From: Graham Nicolls [REDACTED]
Sent: 12 July 2021 11:18
To: Kathryn Welch <Kathryn.Welch@arun.gov.uk>
[REDACTED]
Subject: REF: AB/76/21/I and AB/75/21/HH

Dear Kathryn, in response to the report from Brian Bannister at The Conservation Area Advisory Panel dated 07.07.2021 regarding the above application I have the following comments:

PROPOSED DETAIL FOR
 WINDOWS W6, W7, W8 + W9
 WHICH WILL BE DOUBLE GLAZED

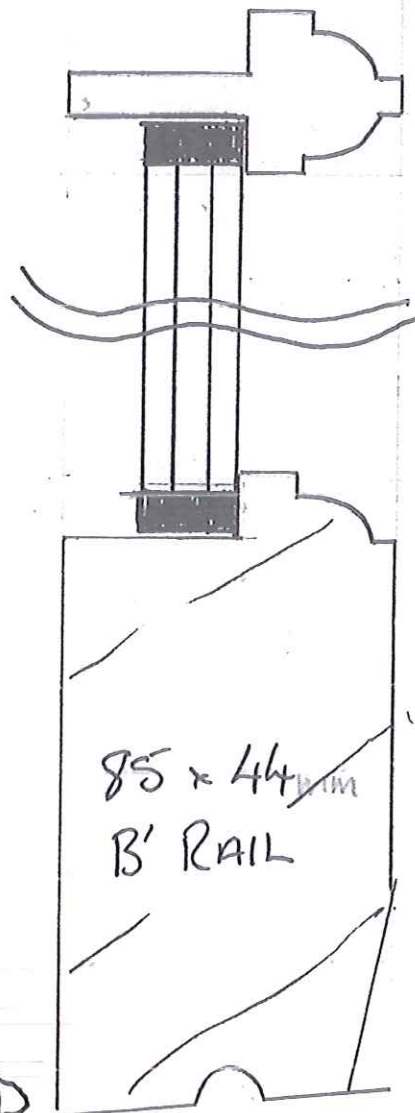
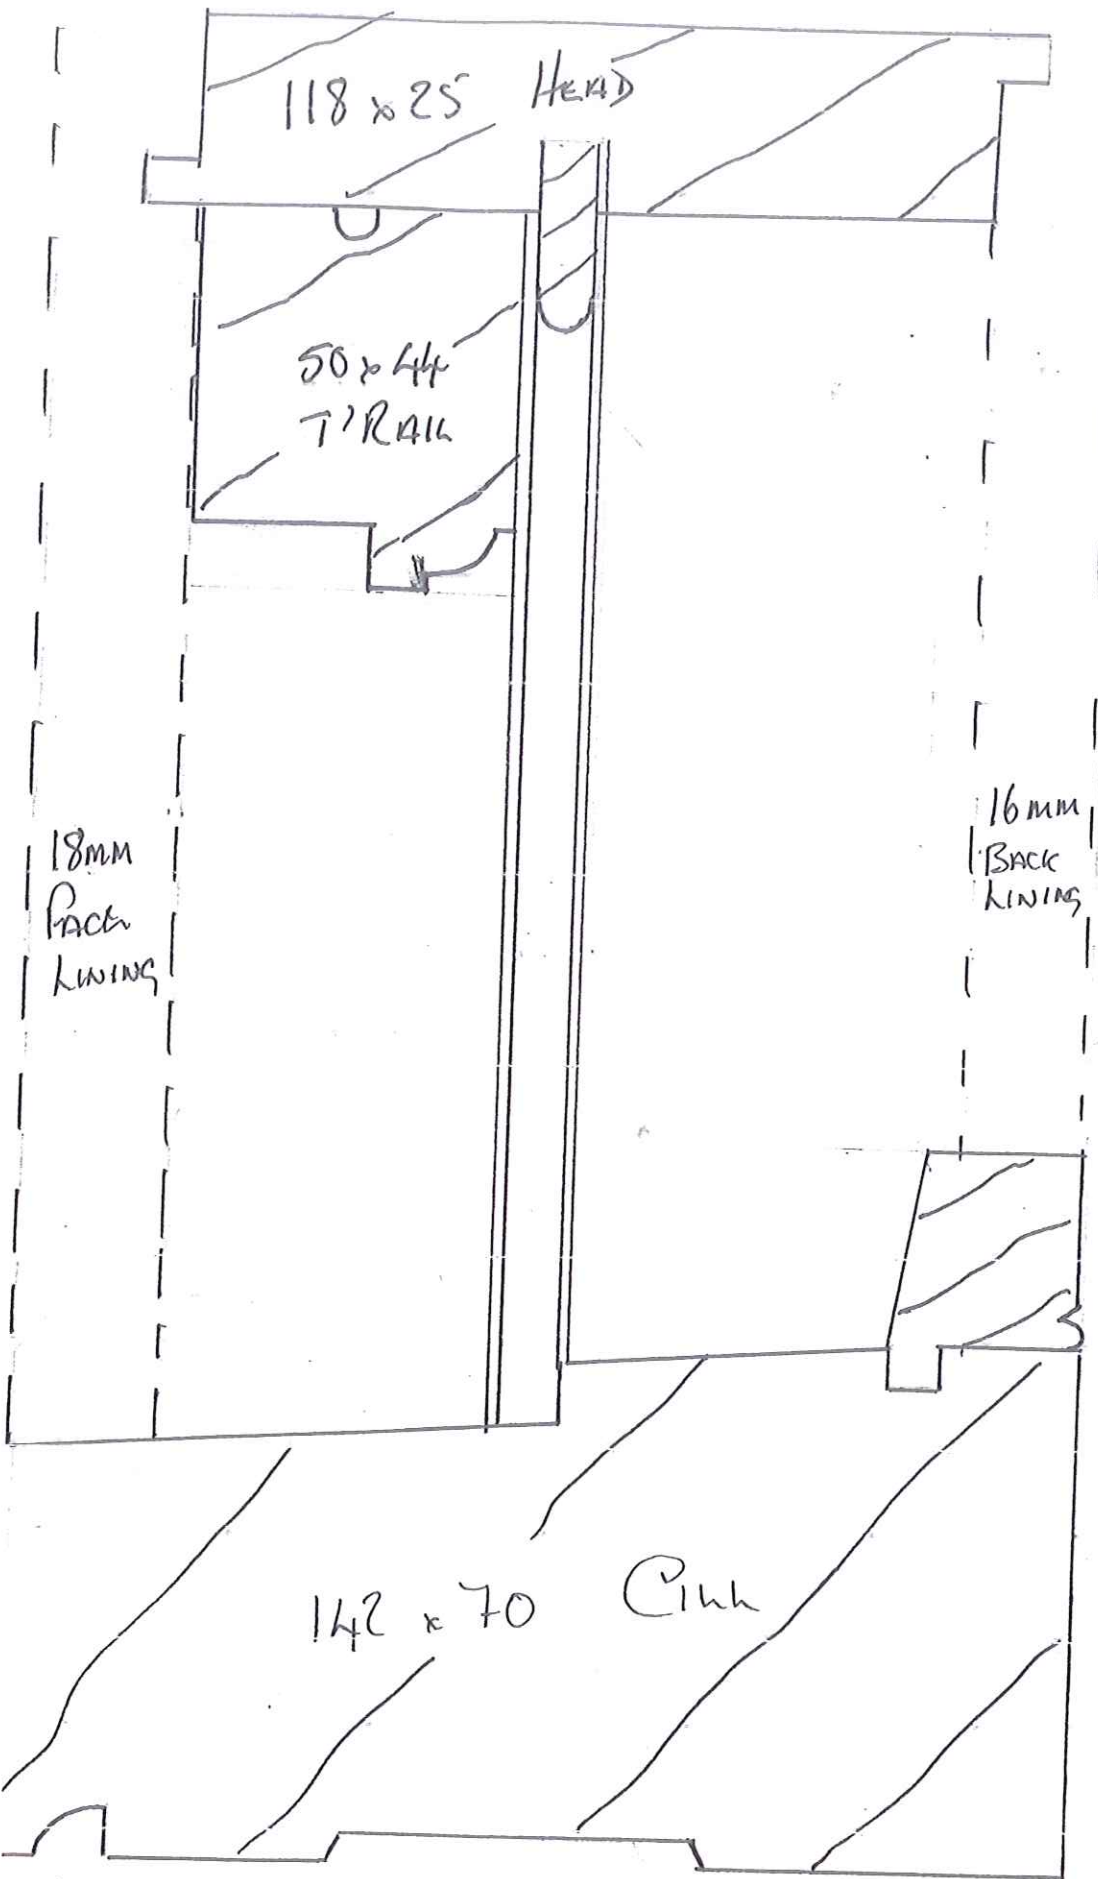
1. We note the objection regarding double glazing but as you will see from the application Martyn White has already addressed this matter and concluded that windows in upper stories can be acceptable.
2. In the side elevation of Avola House Arundel at low level in Bakers Arms Hill there has recently been approved and, installed, a double glazed semi-circular window set into a new frame.
3. Regarding the condition of windows for which we are seeking approval, an inspection was undertaken by a window specialist but not collated or linked to the window reference numbers shown on the application. This is now being checked and will be submitted as soon as possible. Can you please advise by when this needs to be on your desk.
